Portishead Branch Line (MetroWest Phase 1)

Planning Inspectorate Reference: TR040011

9.3.11 ExA.SoCG-ASP.D1.V1 – Statement of Common Ground

- (1) North Somerset District Council; and
- (2) Avon and Somerset Constabulary

Drawing
**PORTISHEAD STATION CAR PARK
LAYOUT, LANDSCAPING AND NEW
BOULEVARD AND ACCESS PLAN
SHEET 1 OF 3**

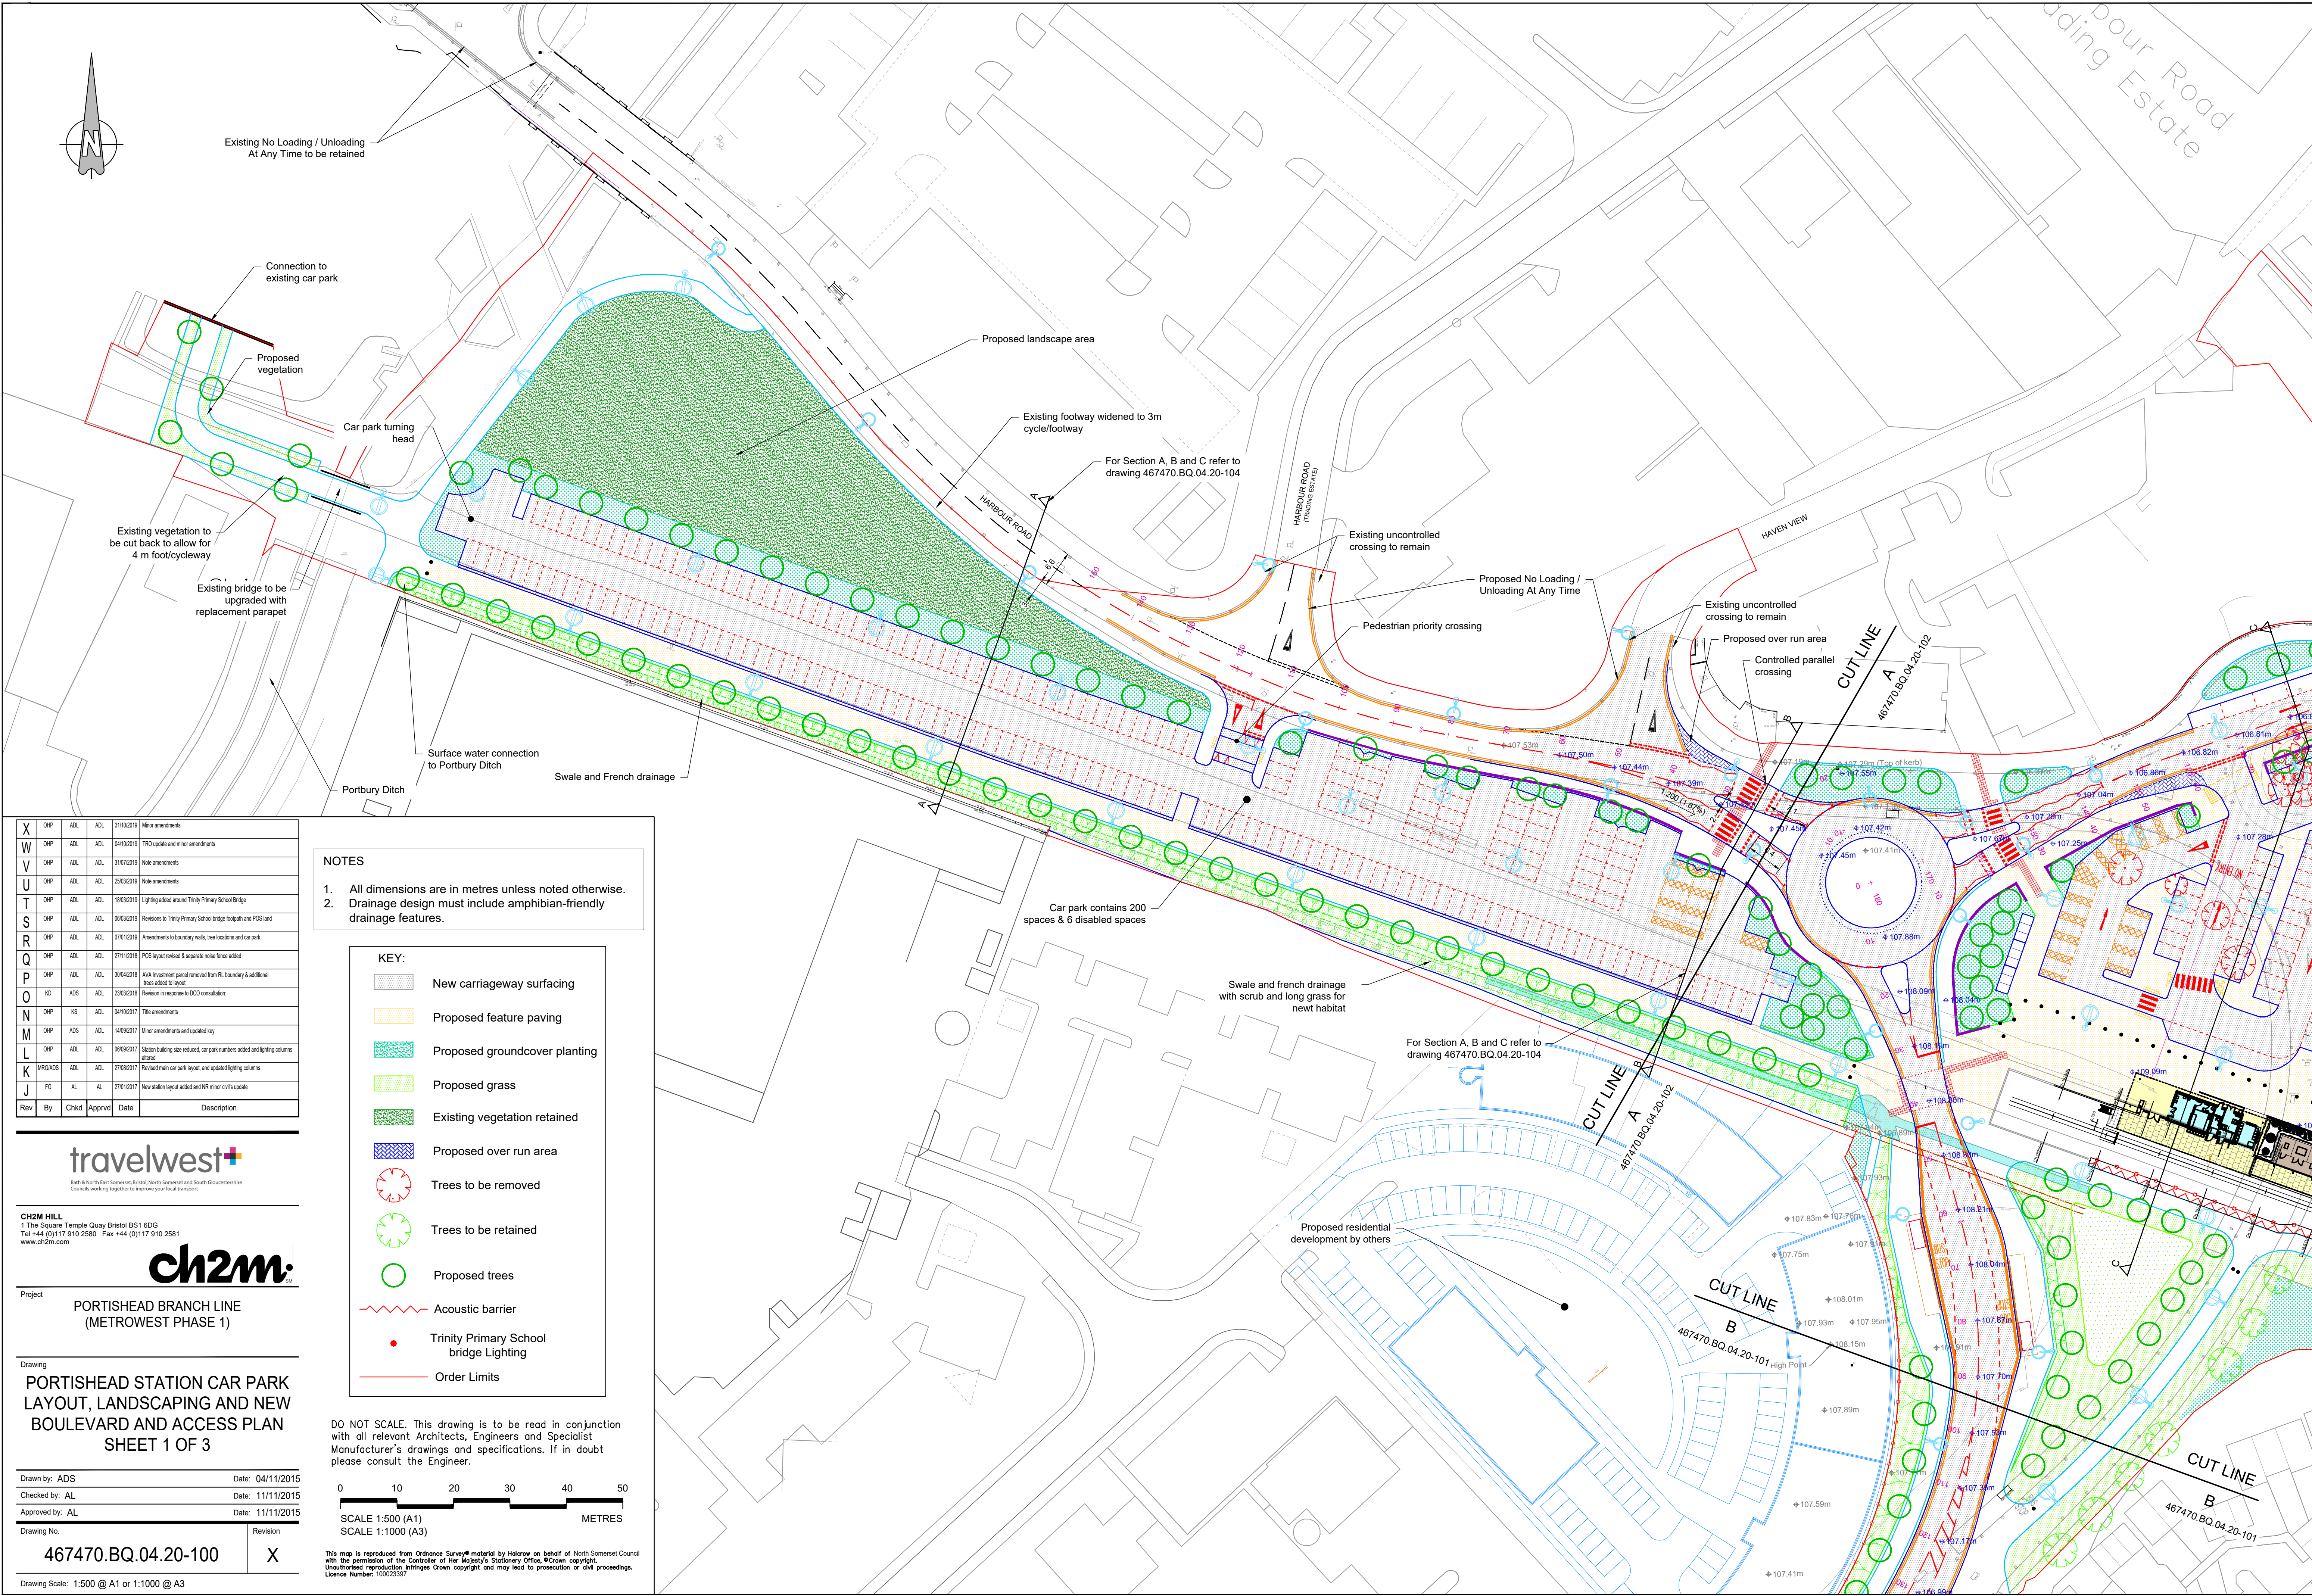
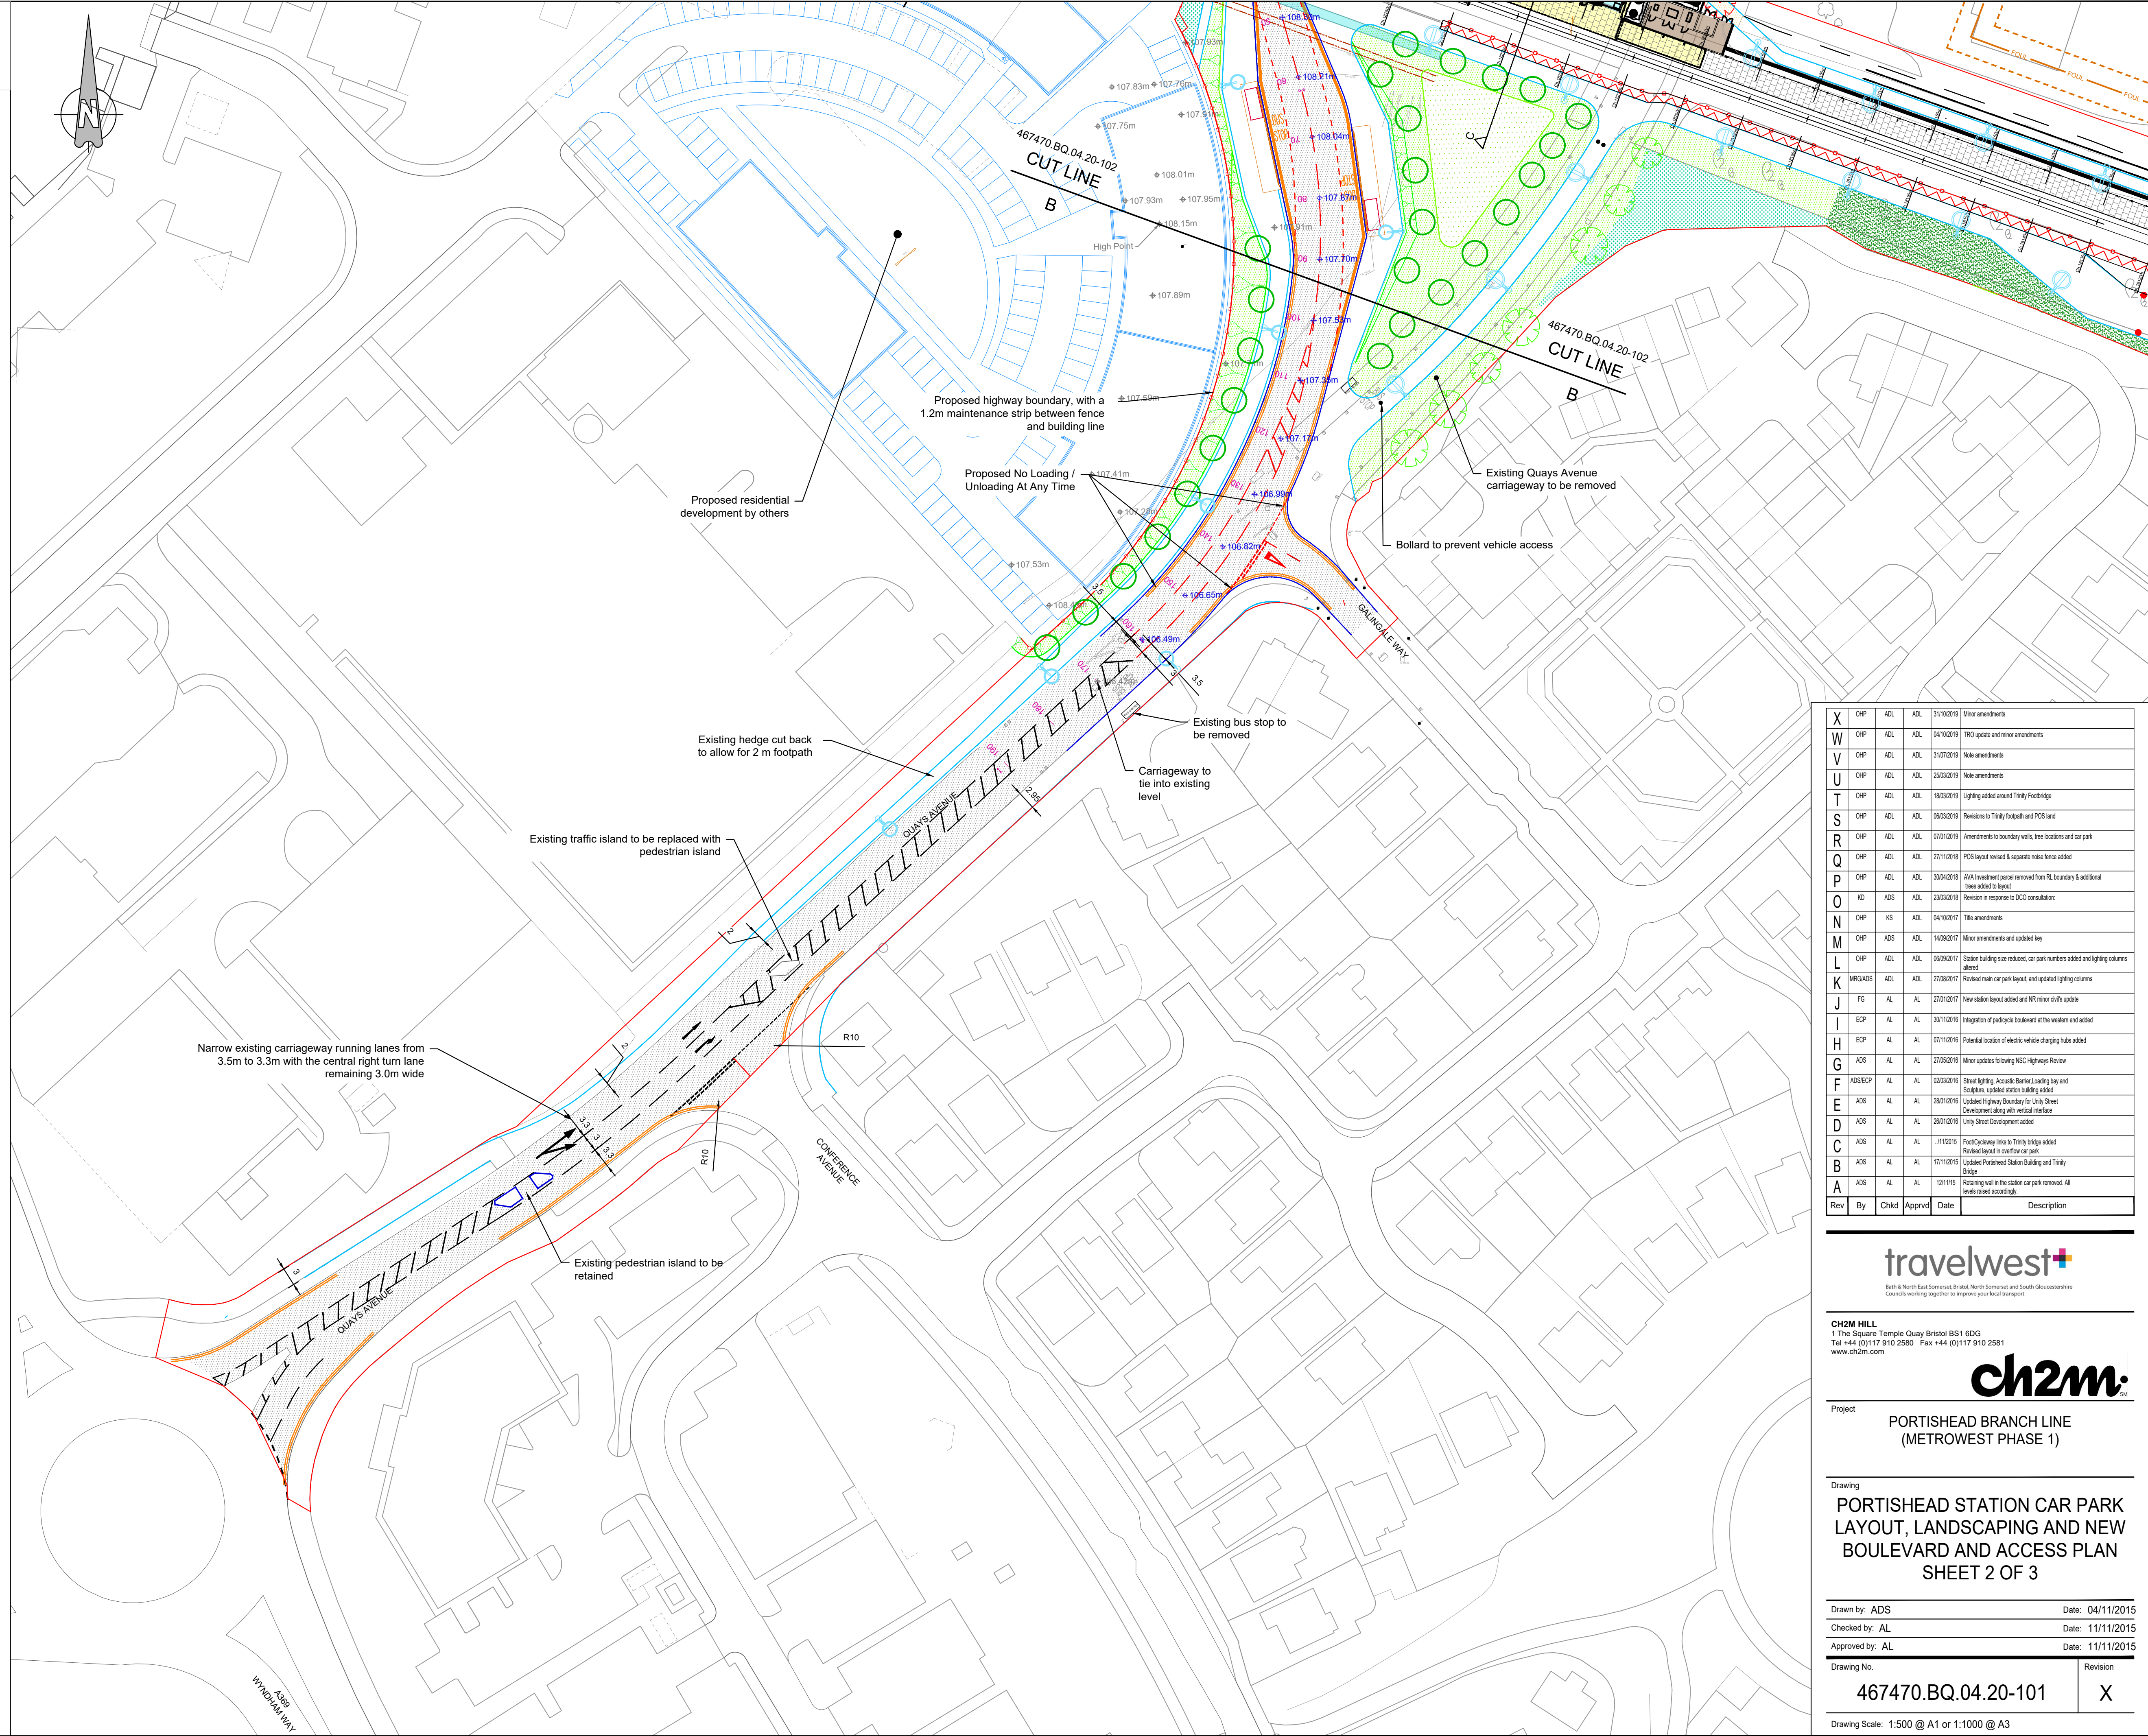
Topic	Avon and Somerset Constabulary position	Applicant position	Status
Portishead and Pill station car parks	<p>Stated concerns regarding:</p> <ul style="list-style-type: none"> • design allows vehicle and pedestrian access day and night; • height restriction or barriers on the entrance to prevent misuse of the car park when the station is closed. 	<p>The car parks will not be used exclusively by station users and will have 24-hour operation.</p> <p>A height restriction barrier is proposed for both Portishead and Pill. The details of which will be included in the detailed designs after the DCO Application submission.</p>	Agreed
Portishead Station security	Requested use of bollards/street furniture to prevent vehicle access onto large forecourt and pedestrian areas at Portishead Station.	These have been incorporated in the design in line with guidelines, as shown on the station designs. At Portishead Station the bollards separate the car park from the station building, and prevent access to the boulevard and pedestrian areas.	Agreed

Portishead Station anti-social behaviour	Requested that the design and locations of seating at Portishead station should be carefully considered so as not to create a climbing aid or encourage inappropriate loitering or gathering that could intimidate other users of the site.	These concerns have been taken into account when considering seating locations at the station.	Agreed
Reduce risk of bike theft	Requested that cycle parking provision be of the latest security standards and located to	The location and type of stand provision has been carefully considered, balancing all	Agreed
